Planning Authority Ref. F20A/0668
Your Ref. ABP-314485-22

02 April 2024

RE: A proposed development comprising the taking of a 'relevant action' only within the meaning of Section 34C of the Planning and Development Act 2000 which relates to the night-time use of the runway system at Dublin Airport.

Figure 3.1 – Regulatory Decision, Third Condition.
Residential Sound Insulation Grant Scheme (RSIGS) - Initial Eligibility Contour Area - June 2022

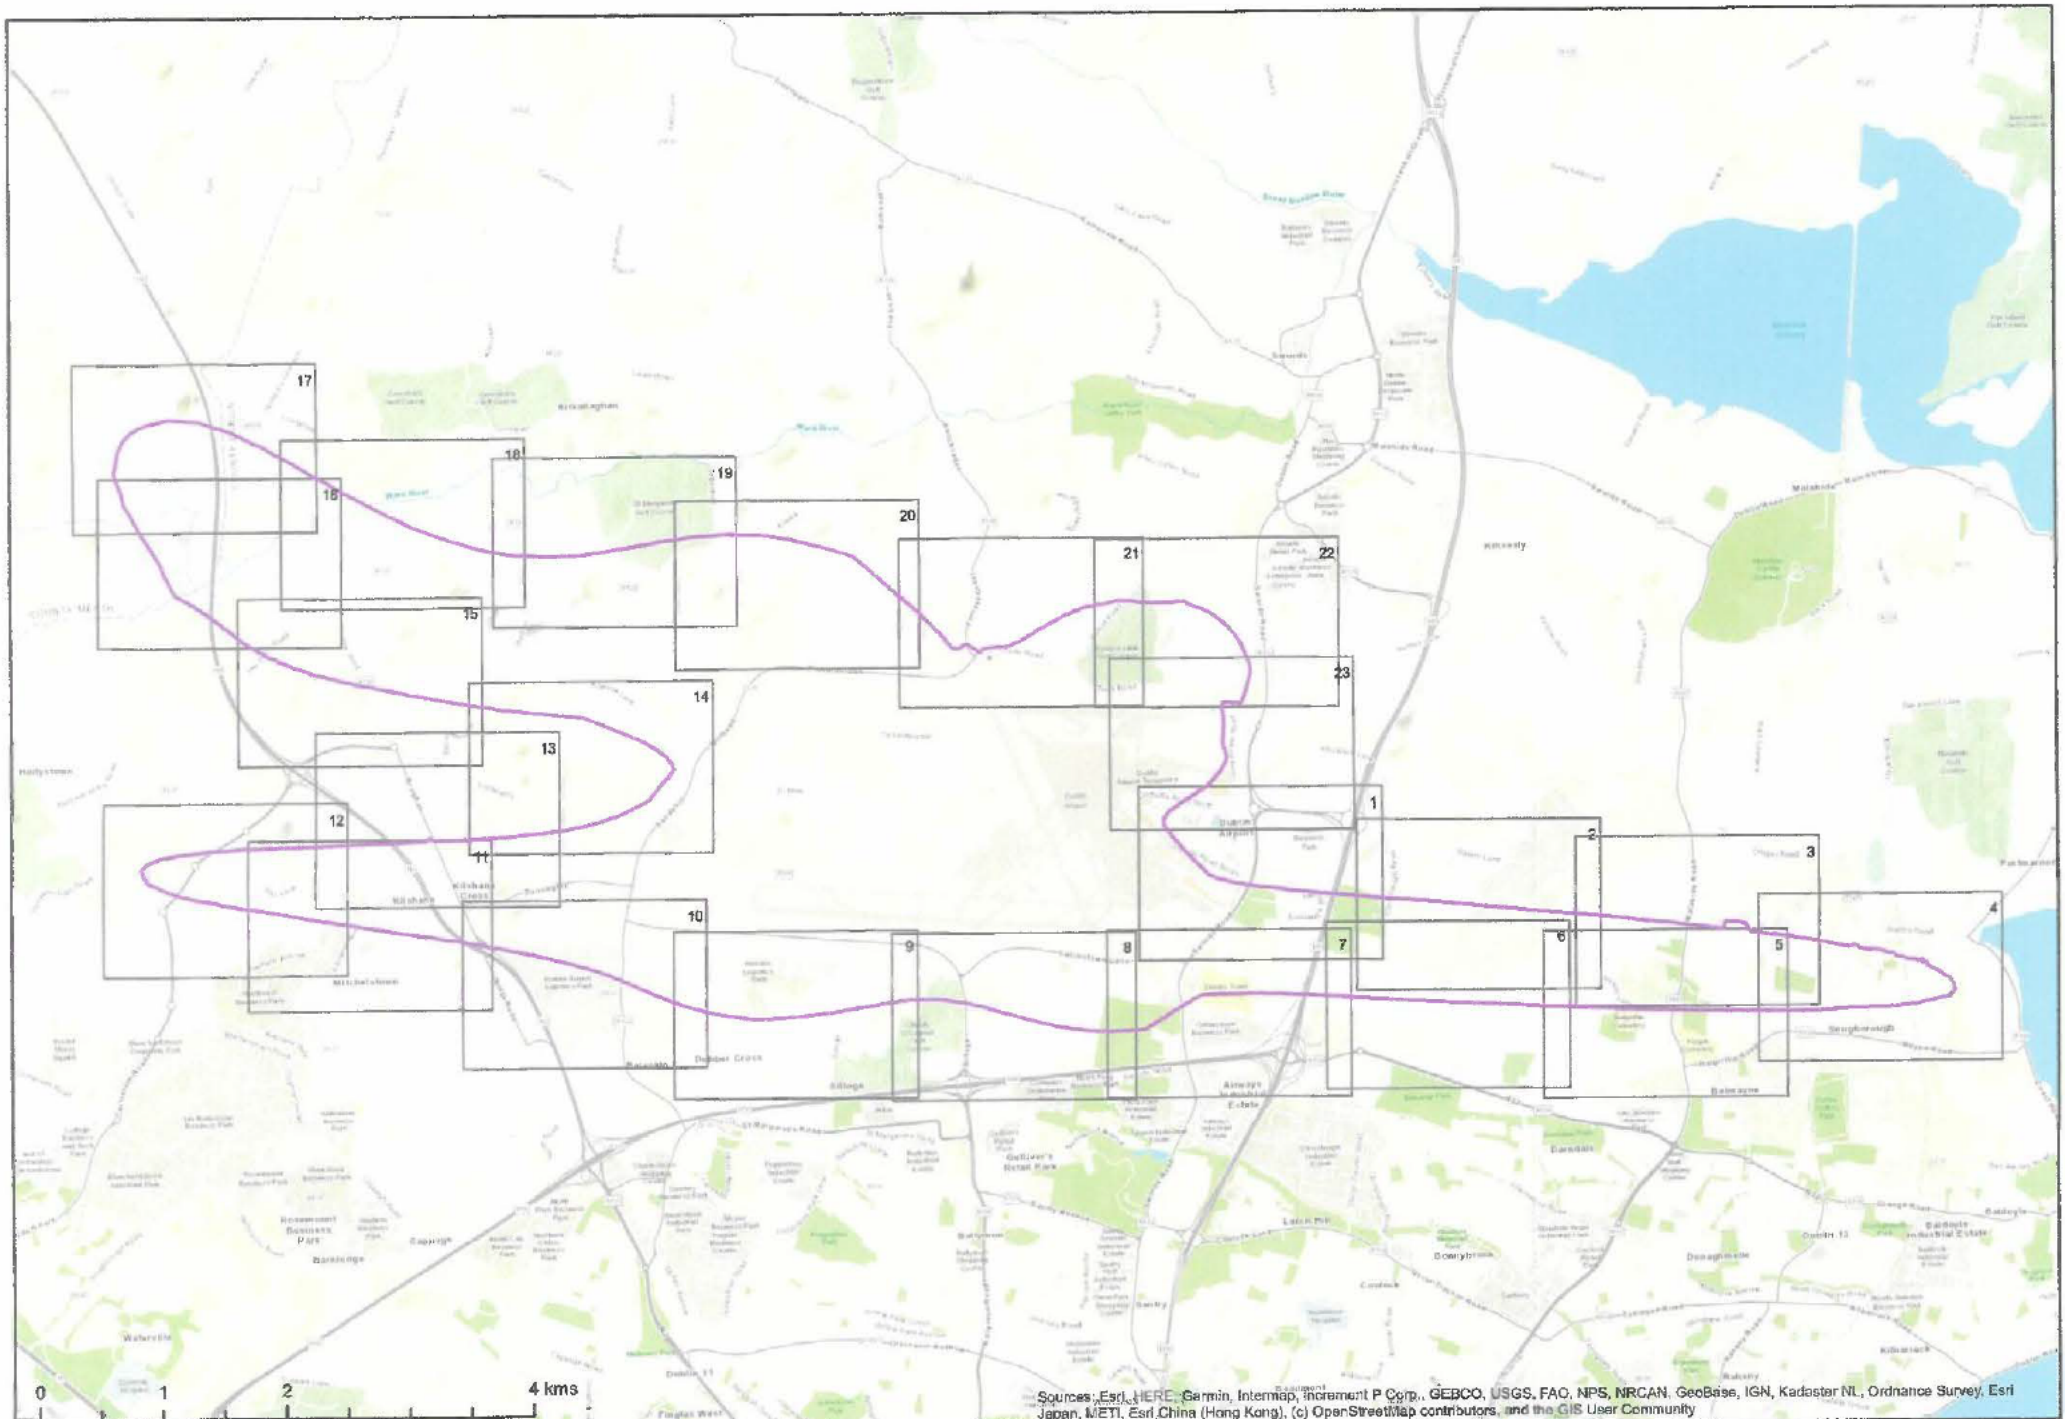
- 2) Although the maps identify dwellings insulated under an existing scheme, or which may have related planning conditions, they do not appear to clearly identify un-insulated dwellings within the eligibility contours. ANCA has observed that it may not be possible, from the map details provided, to determine whether buildings shown are "authorised habitable dwellings" or buildings with other uses, such as farms, offices, industrial buildings or outbuildings. ANCA notes the difference between the contour shapes to the east and west of both runways and to the south and west of the North Runway for the June 2022 Initial Eligibility Contour area and the Sept 2023 Eligibility Contour.
